# Eagle Forest Traffic Impact Study (LSC #204230) June 5, 2020

Add PCD File No.  
PUDSP206

# LSC Responses to TIS and Deviation Redline Comments - Eagle Forest

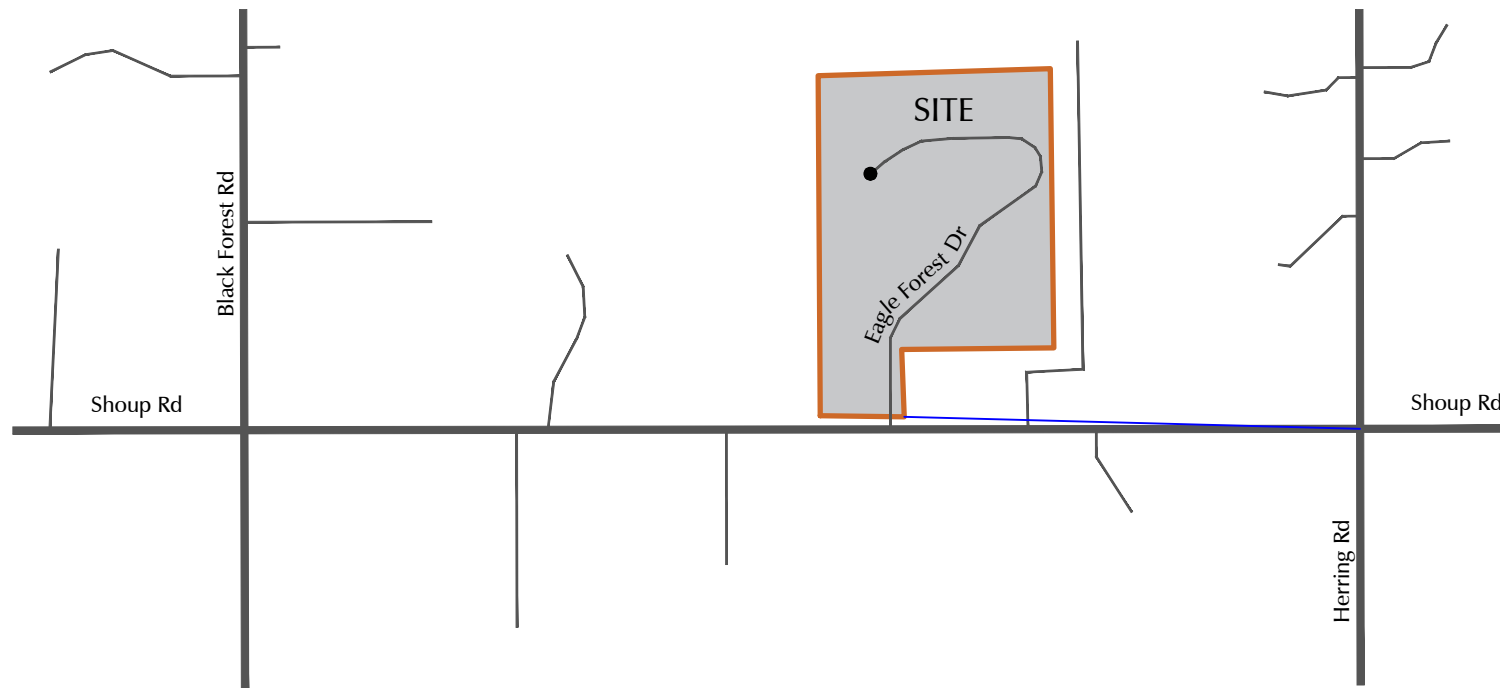
it appears that the proposed roadway meets the intersection spacing requirements per ECM criteria (1/4 mile spacing). Please also state the distance of the proposed roadway to herring road and state that the location of the roadway meets ECM intersection spacing criteria.

it appears that the proposed roadway meets the intersection spacing requirements per ECM criteria (1/4 mile spacing). Please also state the distance of the proposed roadway to herring road and state that the location of the roadway meets ECM intersection spacing criteria.

LSC Response: Added to the report as requested.
